A303 Sparkford to Ilchester Dualling Scheme TR010036

8.4 Statement of Common Ground with Somerset County Council and South Somerset District Council

STATEMENT OF COMMON GROUND

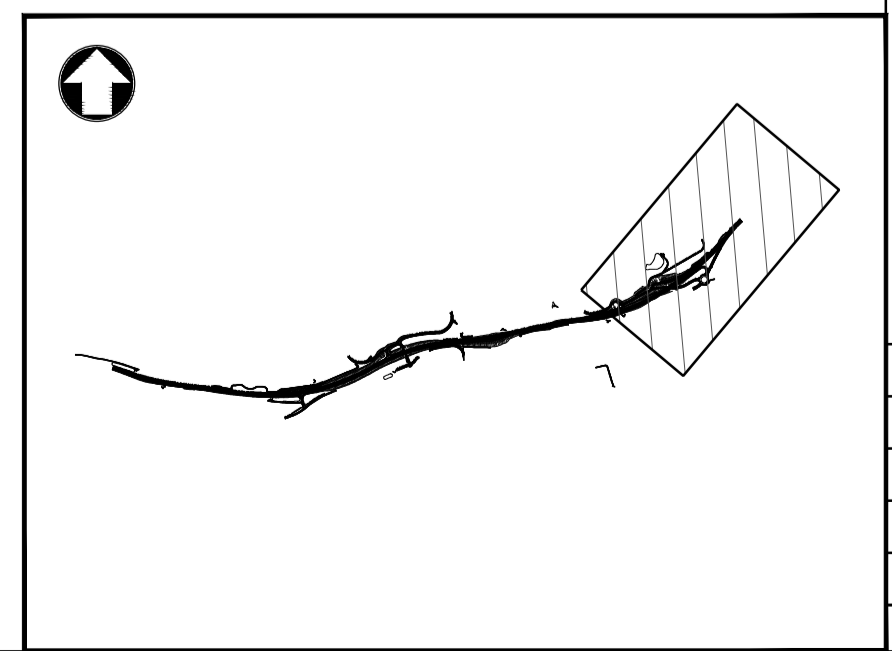
Lighting	Responsibility for proposed system of lighting at Hazlegrove Roundabout is yet to be resolved, although SCC's view at this time is that Highways England would retain maintenance responsibility.	Noted, although this is a detailed design point and so the Applicant is not in a position to agree this at stage.	NOT AGREED
Drainage	Detailed drainage proposals confirming that only surface water runoff from the local highway network discharges to Pond 4 will need to be submitted before SCC are able to accept maintenance responsibility for this pond.	Noted.	AGREED
